Application no: 18/00459/DISC

Proposal: Discharge of condition 7 (Means of access to highway) 8 (internal access) 9 (driveways etc) of 14/02156/OUT

Location: Land South Of Cotefield Business Park Phase 2 Adj To Blossom Field Road Bodicote

Transport Development Control

Road 7  
Horiz. 1:500 Vert. 1:50

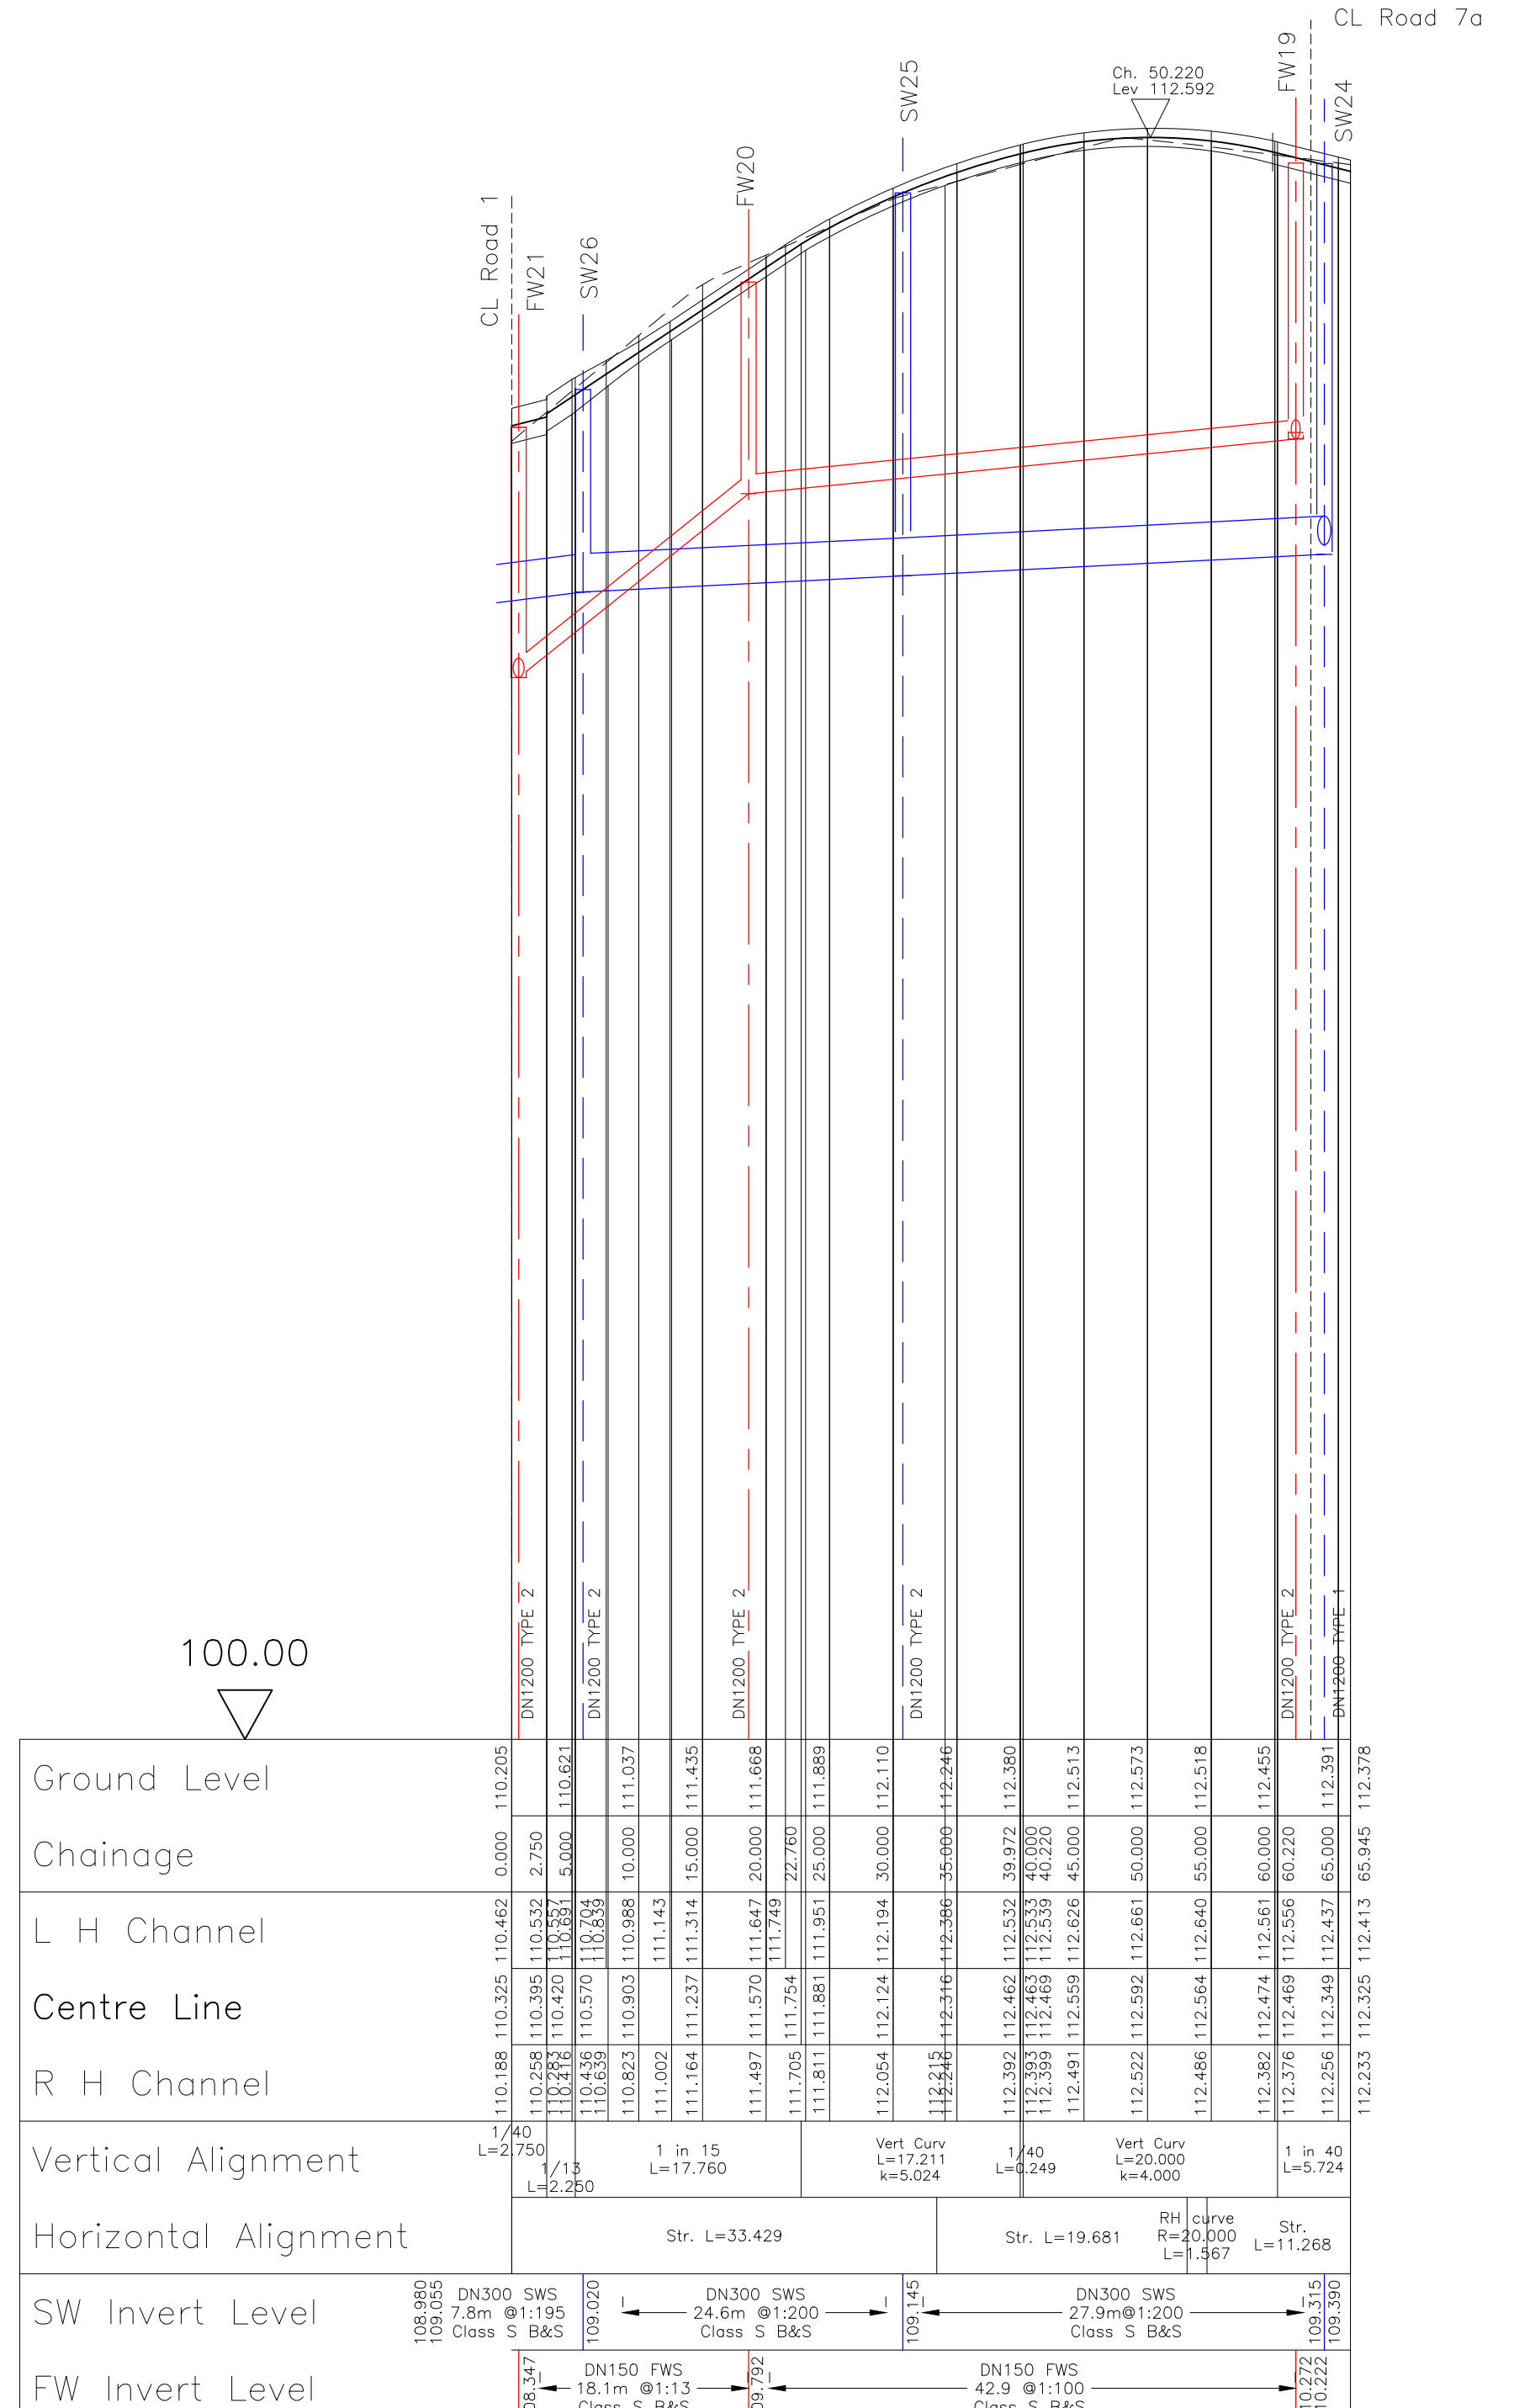
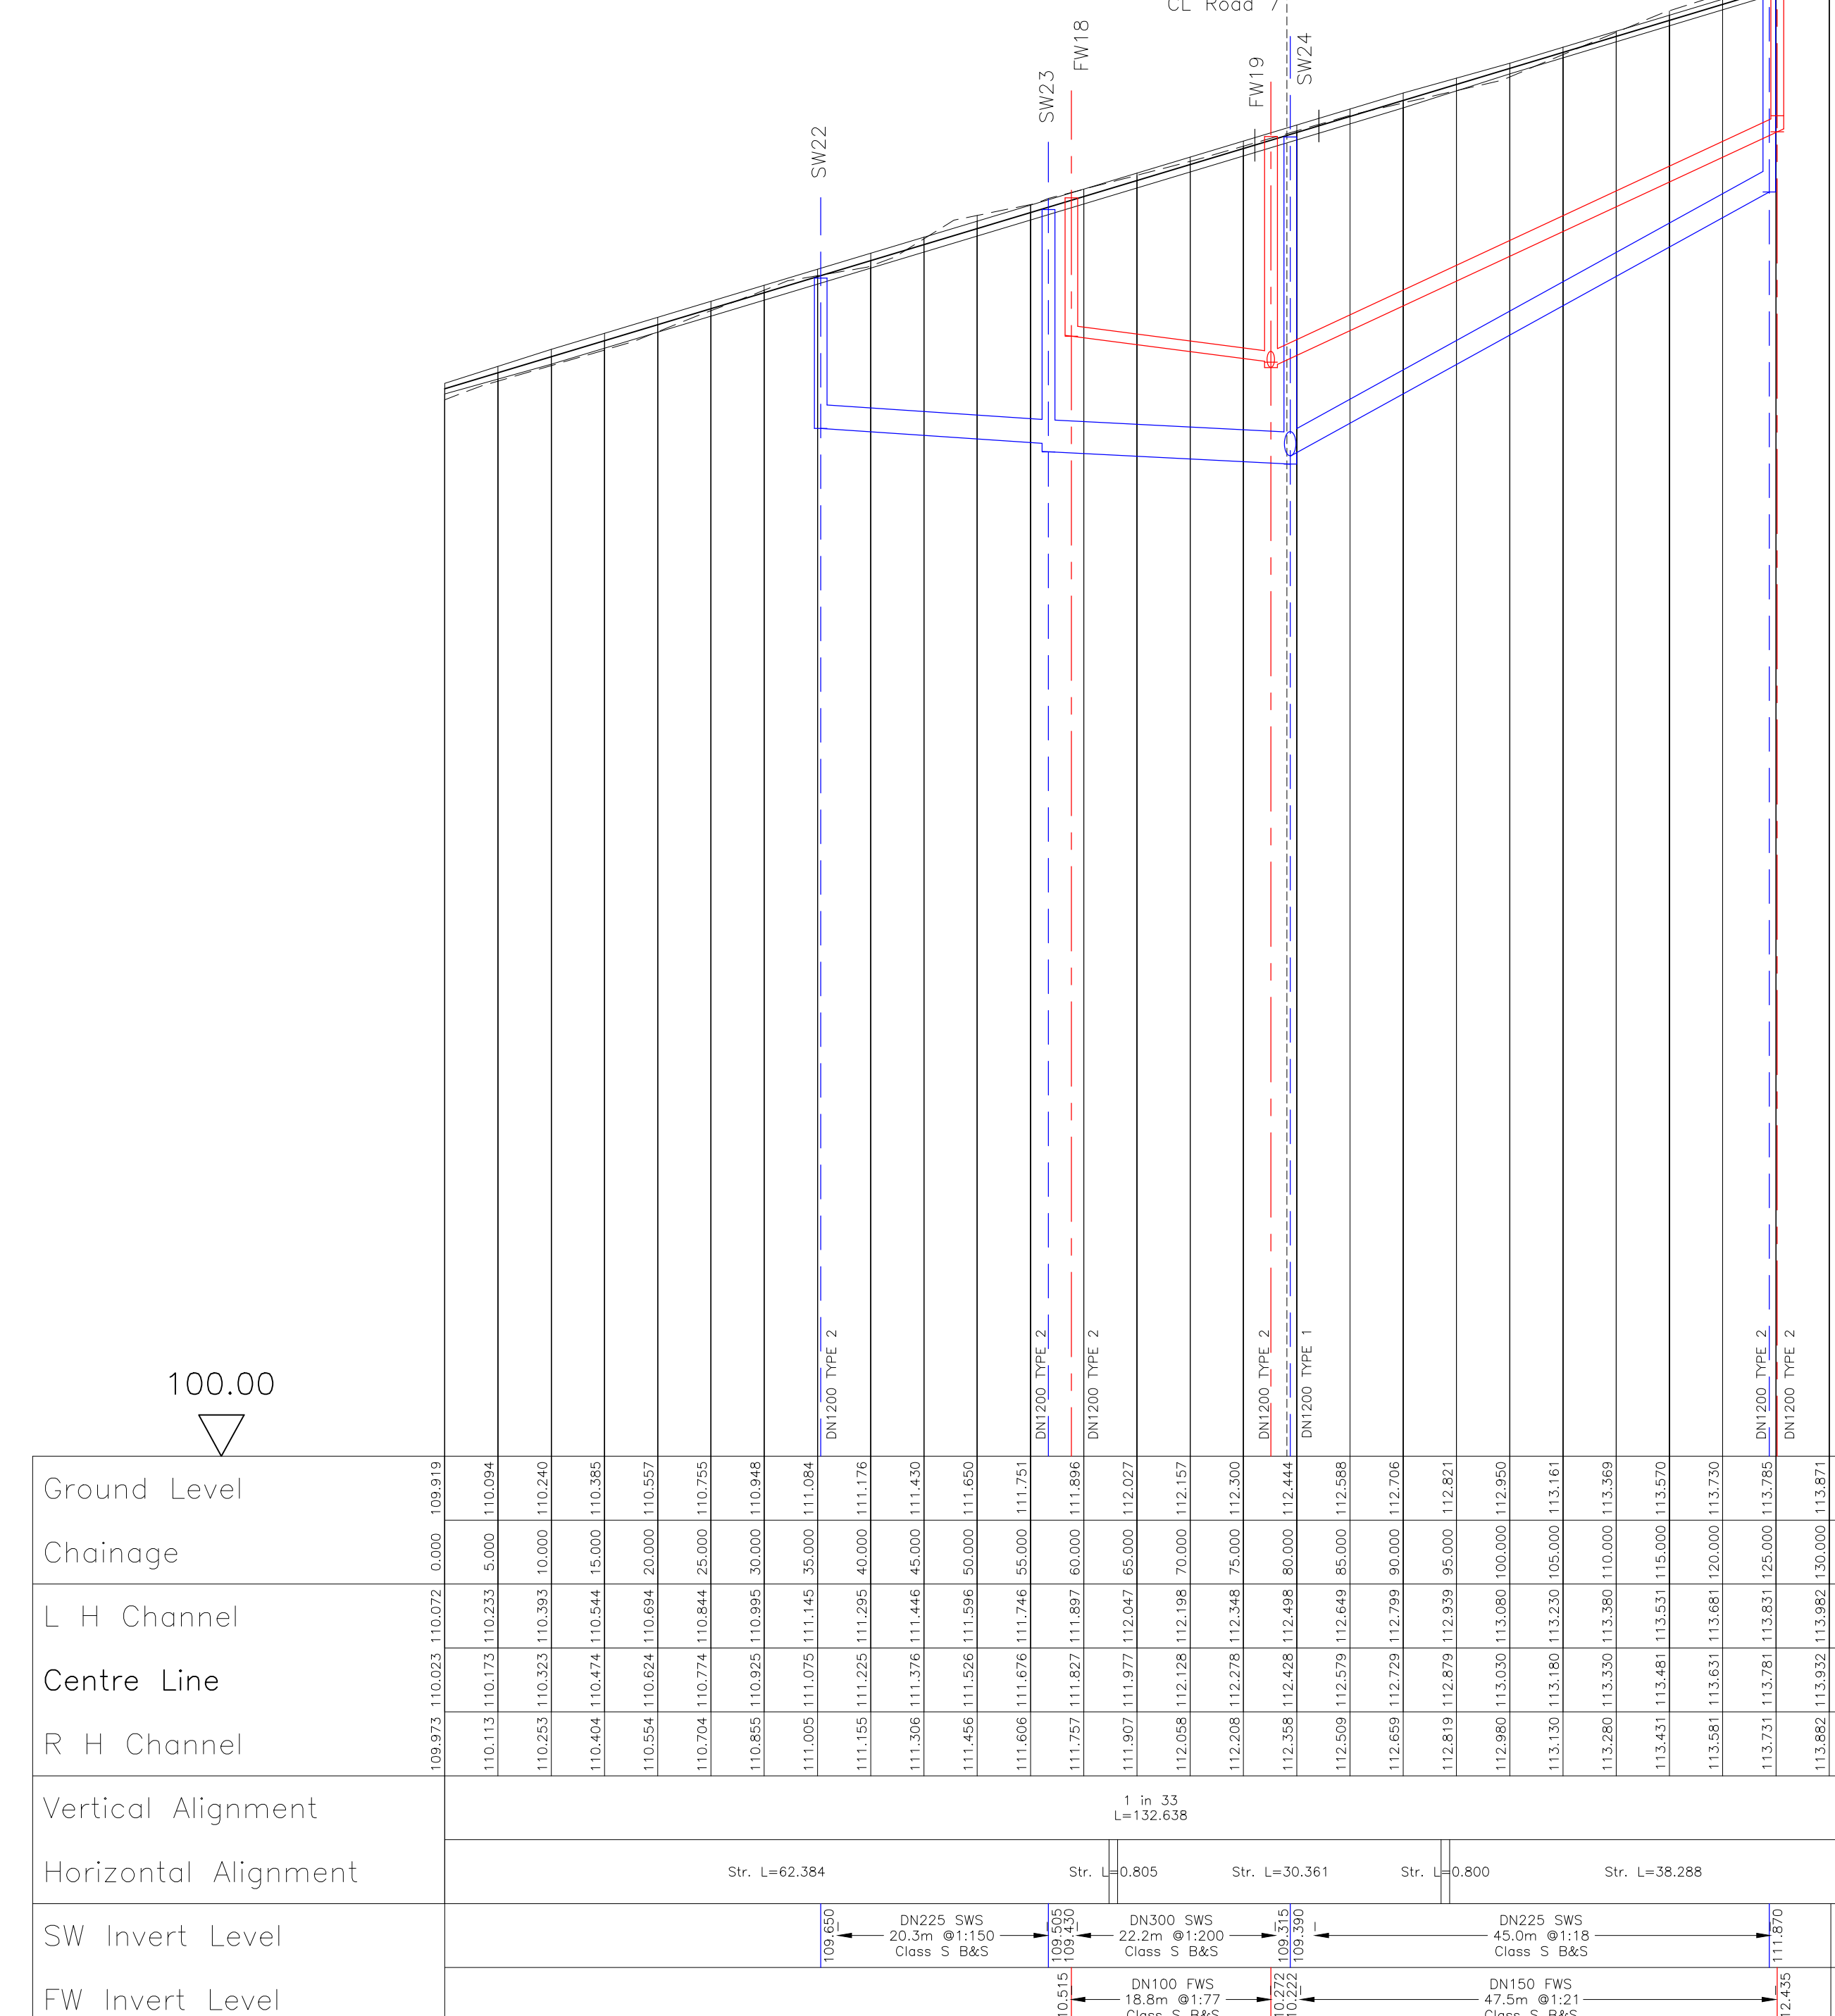
Condition 8 – Internal access – Objection, issues with ground levels.

However, the remaining conditions are a cause for concerns at present for Road Agreements due to the ground levels of the site and this is still currently being determined with them as to how these details can be resolved satisfactorily via the Section 38 audit process.

Please direct the applicant to liaise directly with OCC Road Agreements via the following email address - RoadAgreements@Oxfordshire.gov.uk in order to reach an agreement as how to proceed accordingly.

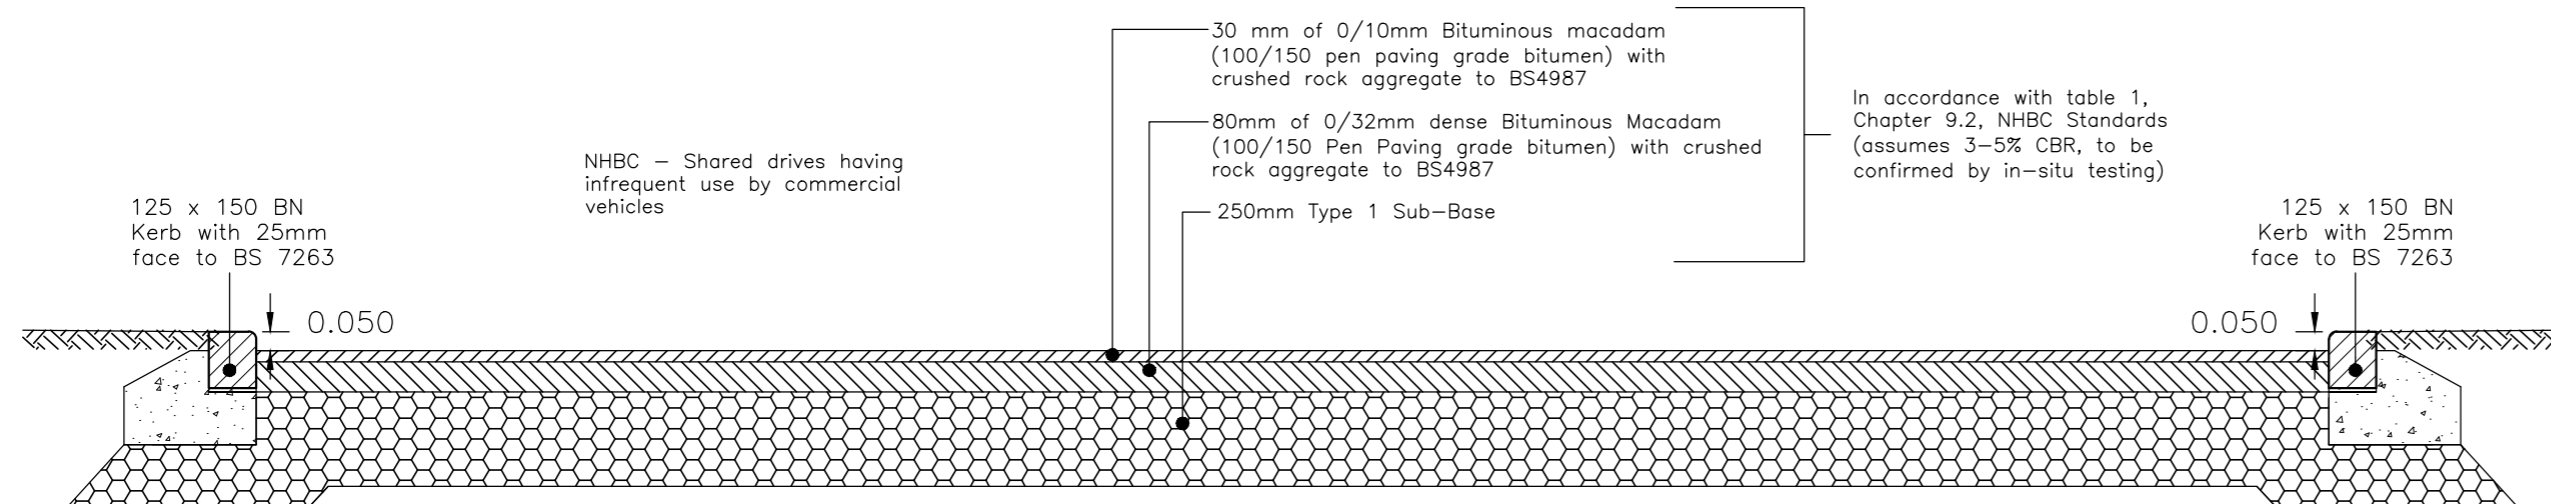
Condition 9 – Driveways – Objection, issues with ground levels.
